Application for Removal or Variation of a Condition following Grant of Planning Permission or Listed Building Consent

Land to the rear of St Luke's, Bierley Marsh

Appeal Ref: APP/Z4718/W/21/3289729

Condition 2 - Approved Plans

client name			
Owens Developments Ltd			
project			
New Dwellings - Land at St Lukes.			
drawing			
Proposed Site Layout			
project number		plot date	
19/157		24/11/20	
drawing number		scale	
104		1:200 @A2	
rev		issue status	
D		Planning Submission

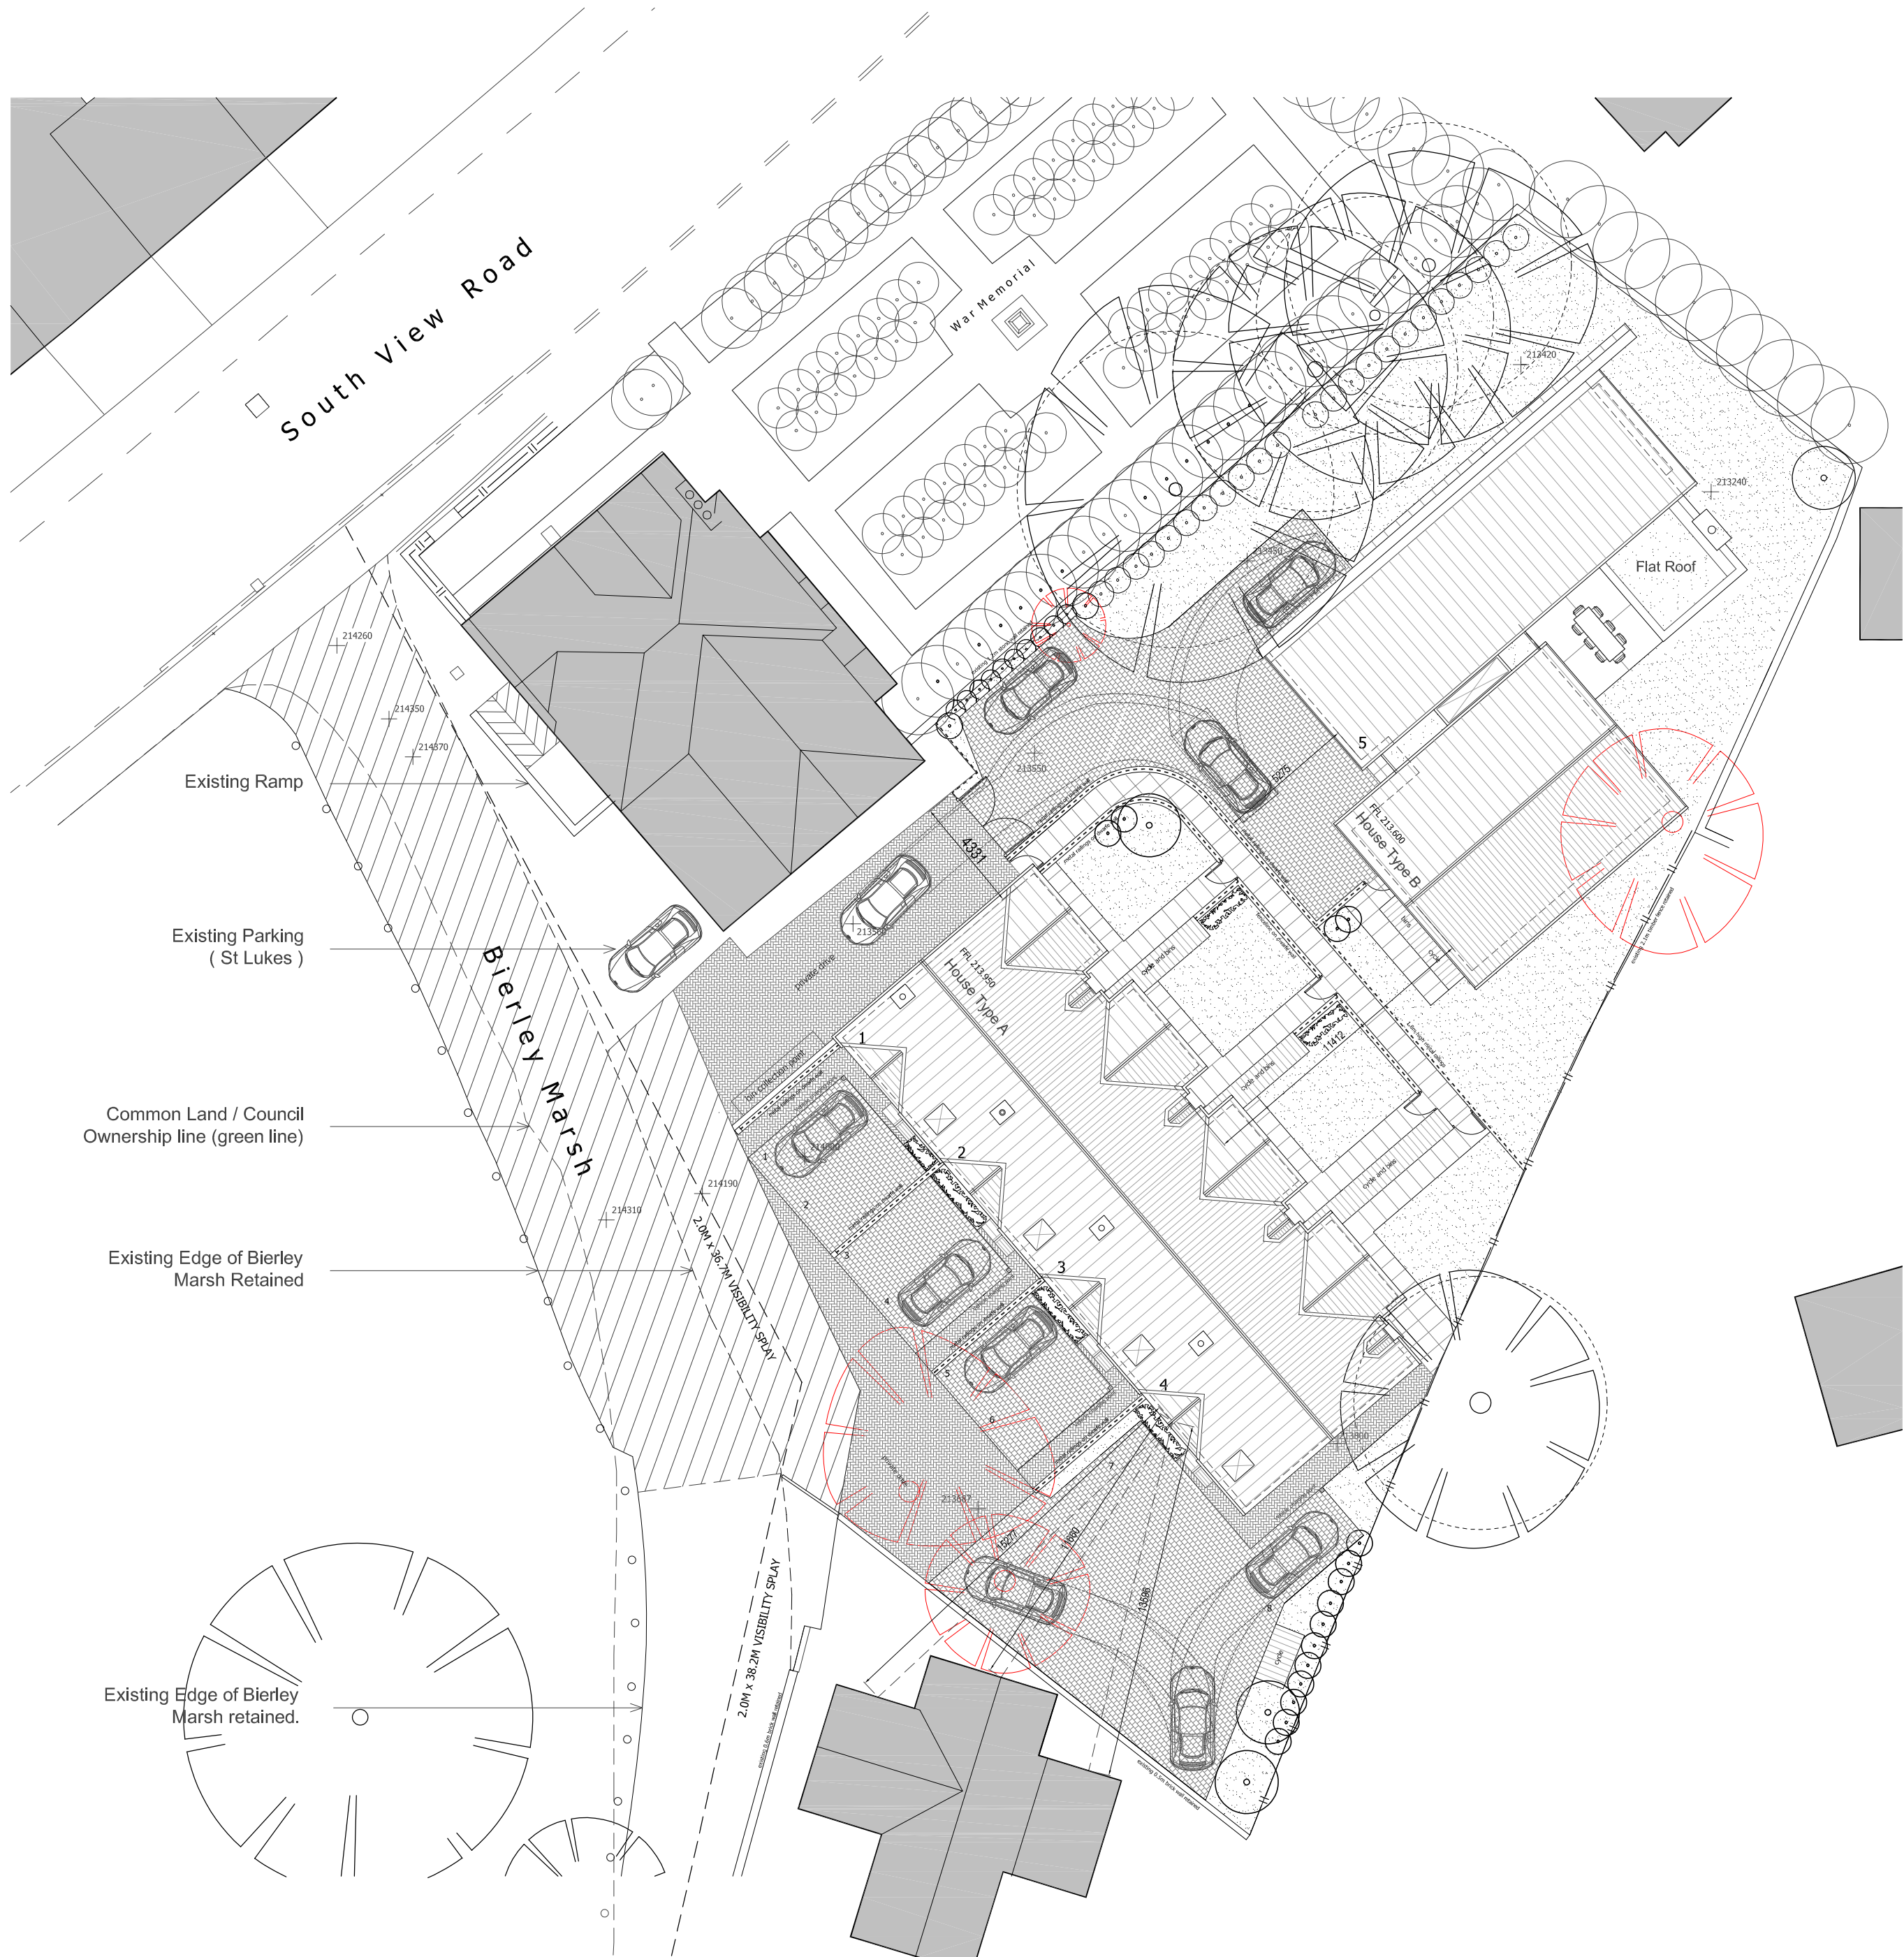
The Appeal Inspector made reference within his decision to the communication received from the Local Authority Highways Officer/Section 38 Team dated 2nd September 2021, which was issued post the submission of the planning application. The result of which is that the consented Proposed Site Layout 104B, listed under Condition 2, does not reflect the detail requirements of the consent as identified within the Decision Notice.

This relates to the change in the original requirement for the road to be made up to adoptable standard. It recognised technical issues with its delivery.

"Following comments received from the Councils Section 38 Team, the proposed access road is not considered suitable for adoption; this is due to constraints in its width and conflict with the existing St Luke's Church Hall access ramp at the side of the building, on the junction of South View Road. In addition, there are several technical issues, which are unable to be resolved to make the proposed road to an adoptable standard.

It is considered that an additional 5 dwellings at the beginning of the access road would not cause any significant or unacceptable highway safety issues. Highway Development Management would however wish to see some improvements to the existing track to bring the road to a better standard, which is recommended to be conditioned. Based on these factors it is considered that, on balance, this proposal would be acceptable from a highway perspective on this occasion, subject to relevant conditions".

"in the event of a grant of planning permission, a pre-development and post-development condition survey of this stretch of Bierley Marsh (within the red line boundary) as well as associated highway improvement works e.g. re-surfacing and associated operations".

It is therefore essential to amend Drawing 104B to ensure they reflect the detailed requirements of the consent. This requires an amendment to condition 2 wording to change the drawing references.

The reference to drawings 104B will be changed to 104D.
